CITY OF ALBUQUERQUE

December 7, 2011

Re: Cantata At The Trails, Pond J Grading Certification
Engineer's Stamp Date 8-09-11 (C09-D001B)

Based upon the information provided in your submittal received 11-29-11, the above referenced plan can not be approved for certification until the following have been addressed.

Sheet No.:  
**C2.04**

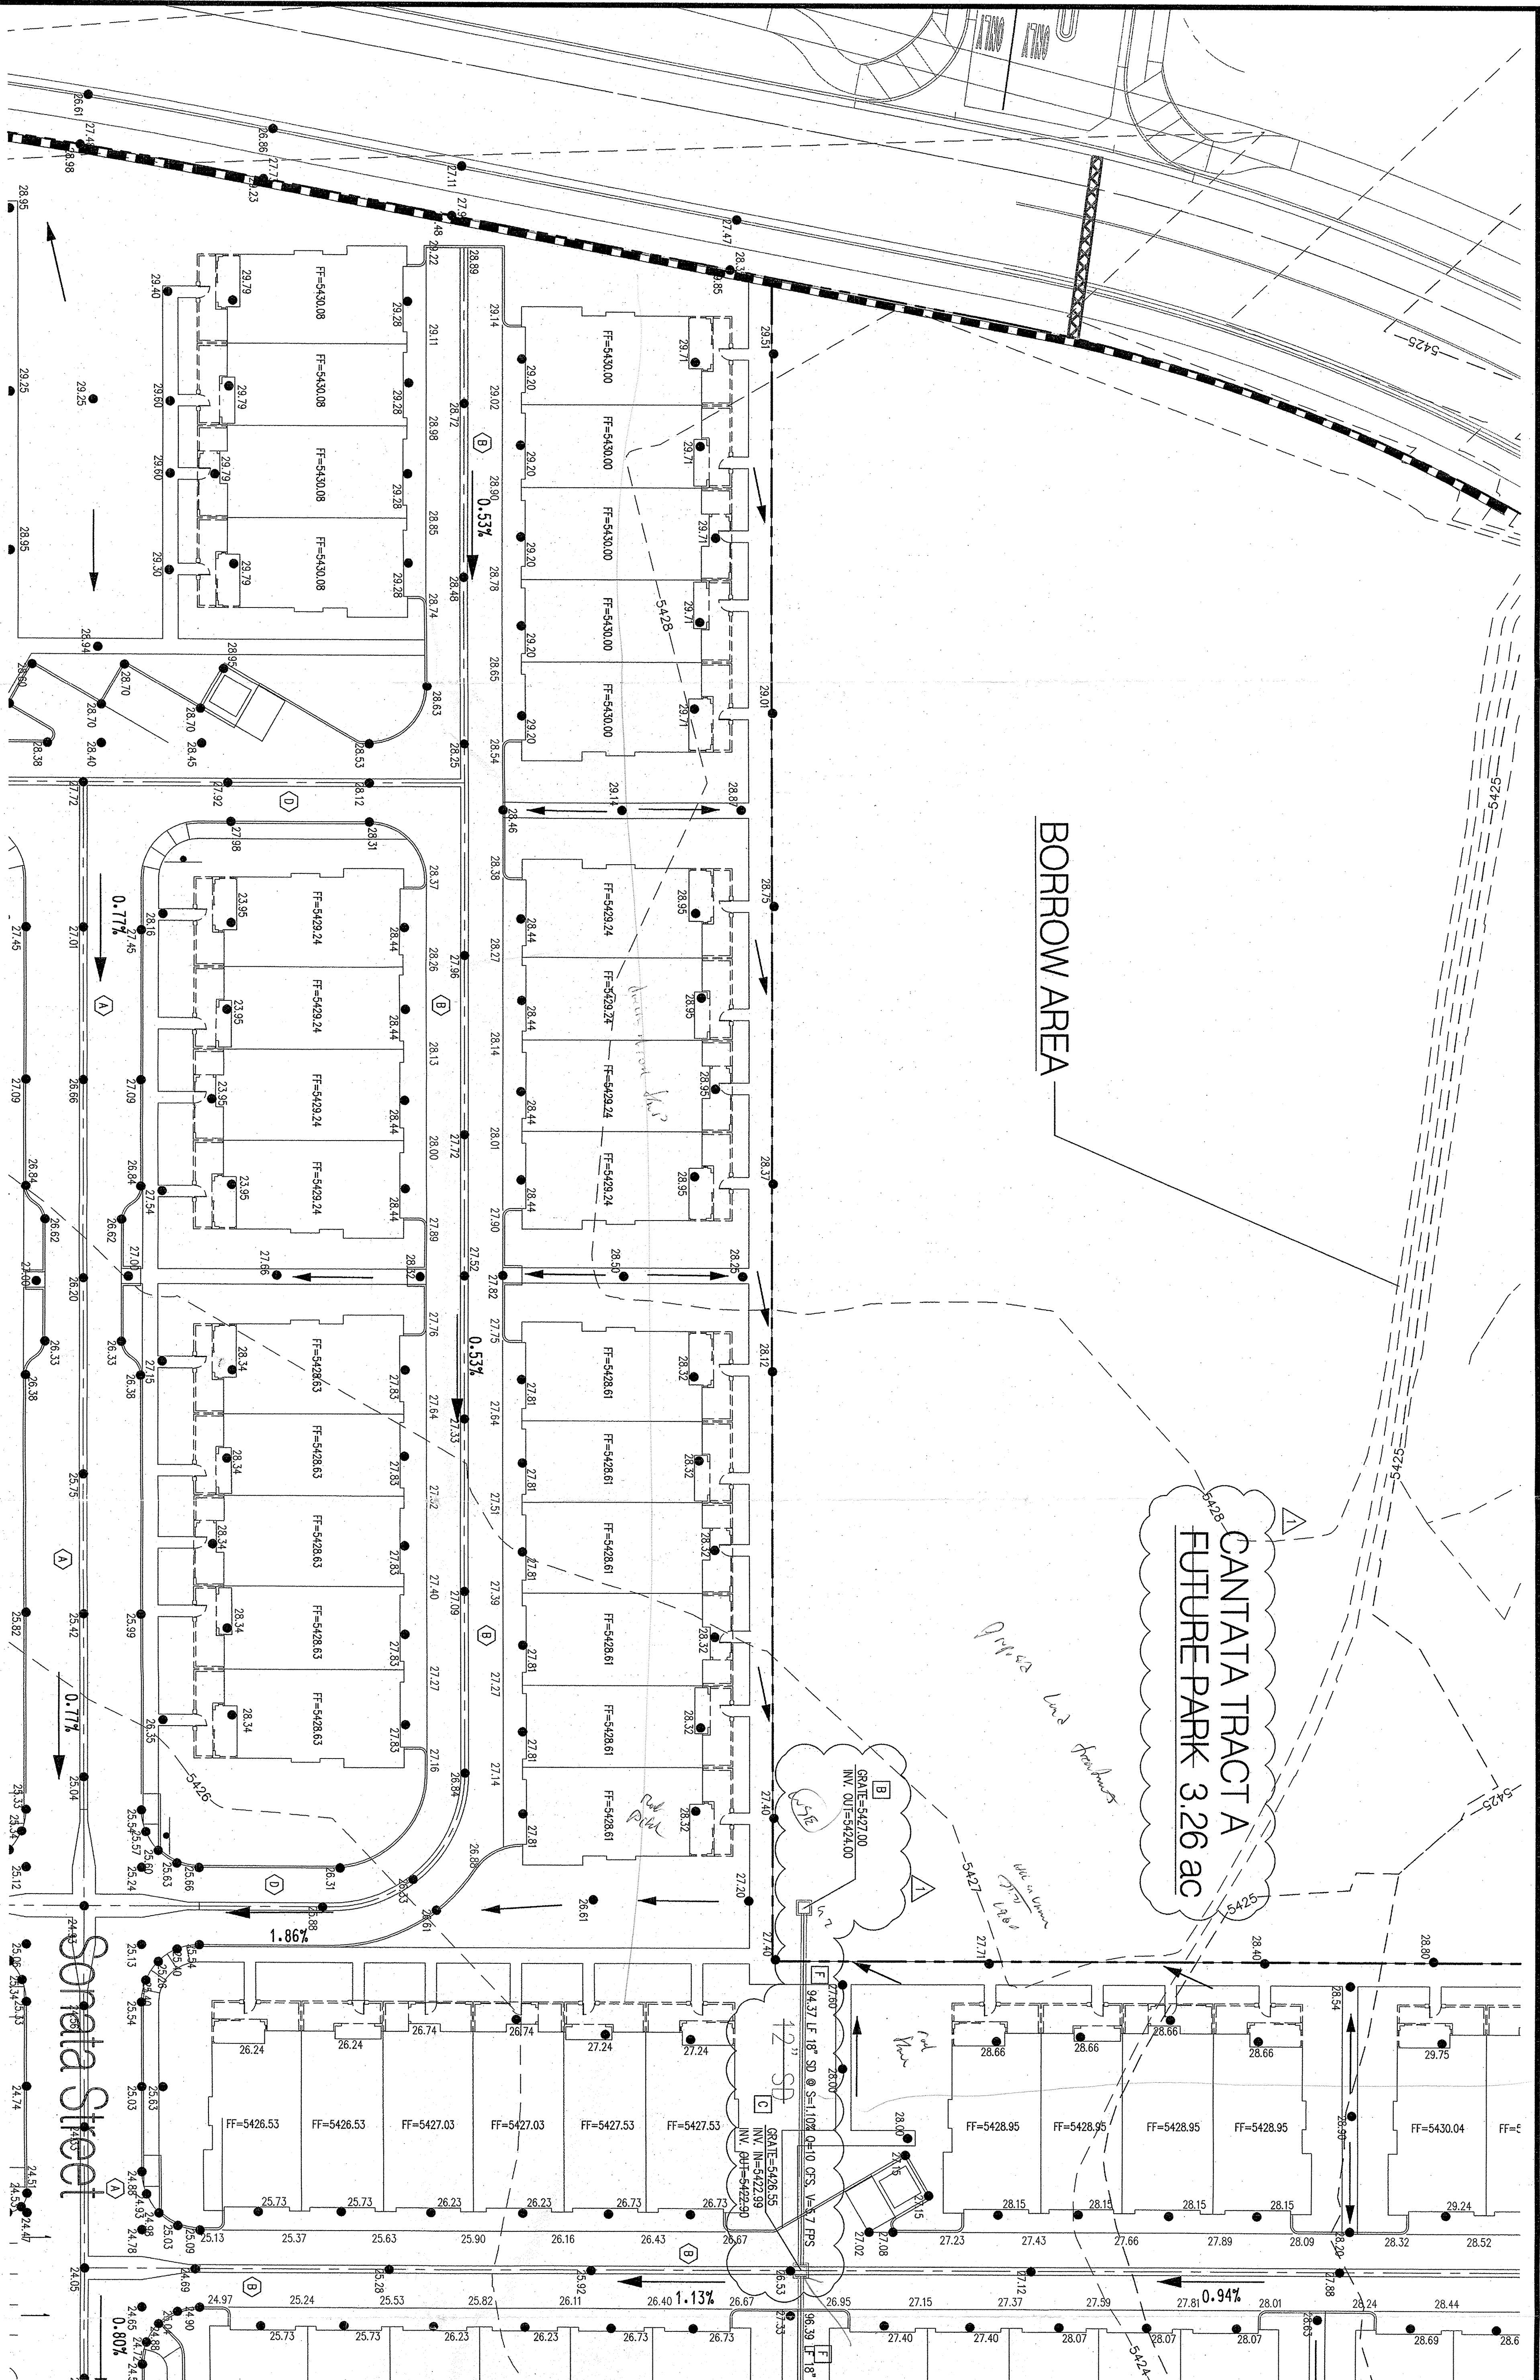
- The existing grades do not reflect the grades on the certification.
- There is approximately an eight foot vertical drop at the 48" storm drain pipe. The grades have to be sloped back or a section pipe may have to be added.
- Please provide a detail with elevations on the emergency spillway. It did not appear to have the wings at the two ends.
